Our ref: PA01138205

18 December 2020

Pre-application Advice

MONKS HALL, SYLEHAM, SUFFOLK

DRAWING
 Proposed Elevations Option 2

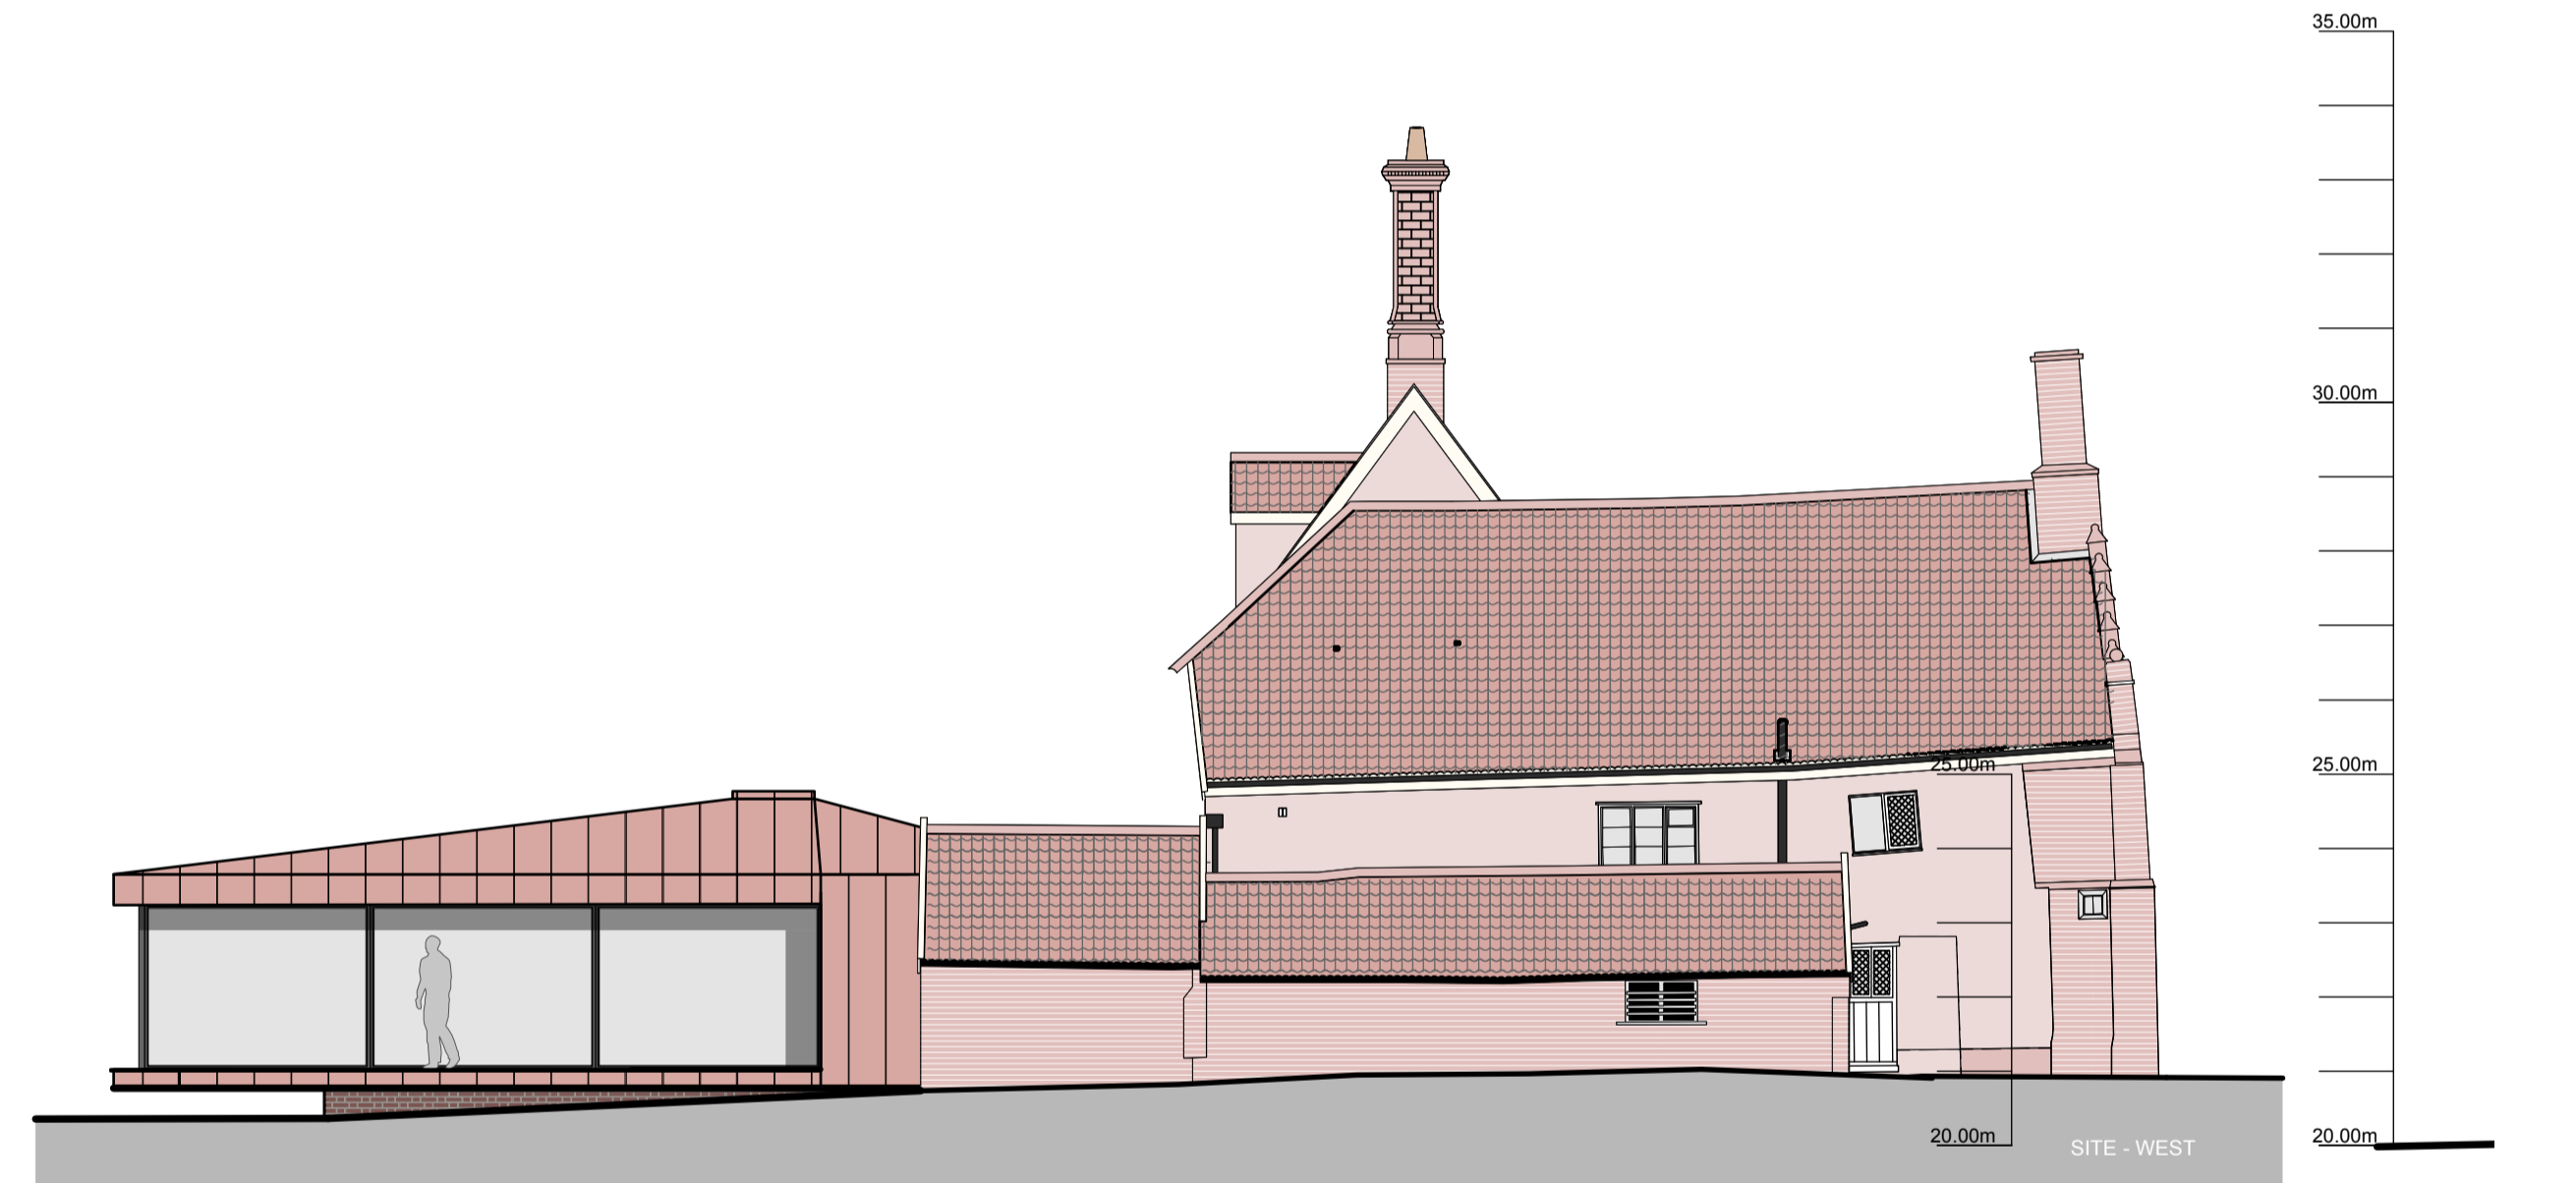
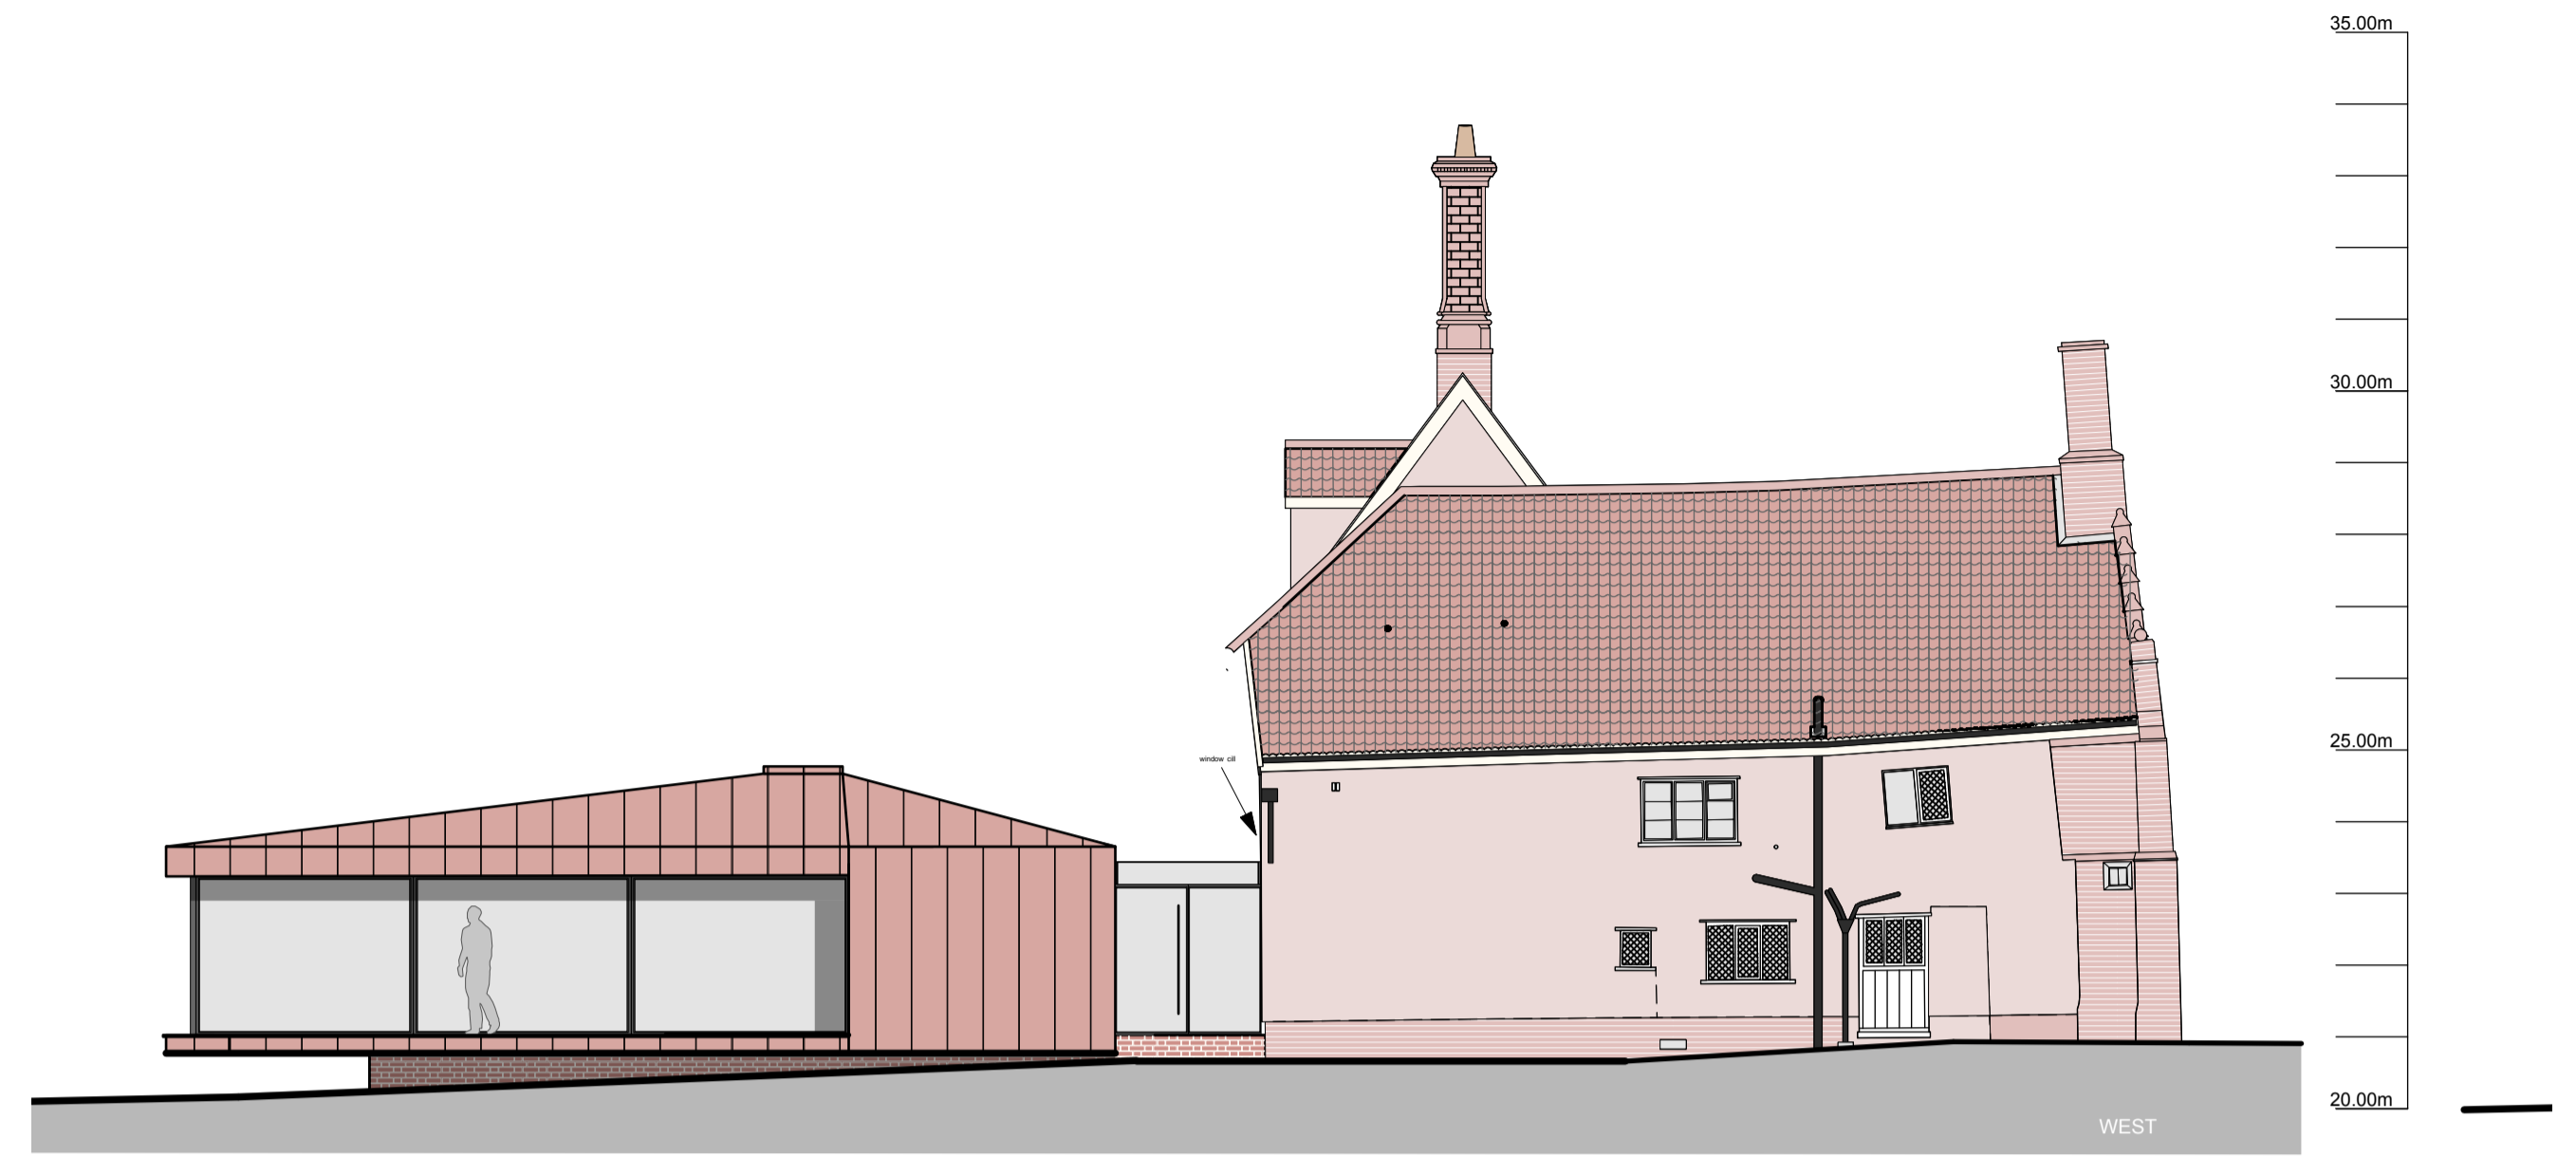
On the ground floor where the extension is proposed, there appears to be the loss of the smaller wooden bay window. What is the significance of this bay window? Also, a downpipe seems to run down in front of a window, is this there at present?

Notwithstanding the above, the proposed area of extension is large and in ground floor space is a similar size to one wing of the main dwelling. We do not consider that this can be considered a subservient extension to the dwelling. The proposed brick wall

between the house and the 'pavillion' appears rather unnecessary and appears awkward against the main house. The link between the outbuilding and the house is less of a link and more part of the extension which makes it appear more dominant. Linking the outbuildings to the house is also questionable as historic maps indicate that these have always been separate and the significance of this is not discussed within the pre-application submission.
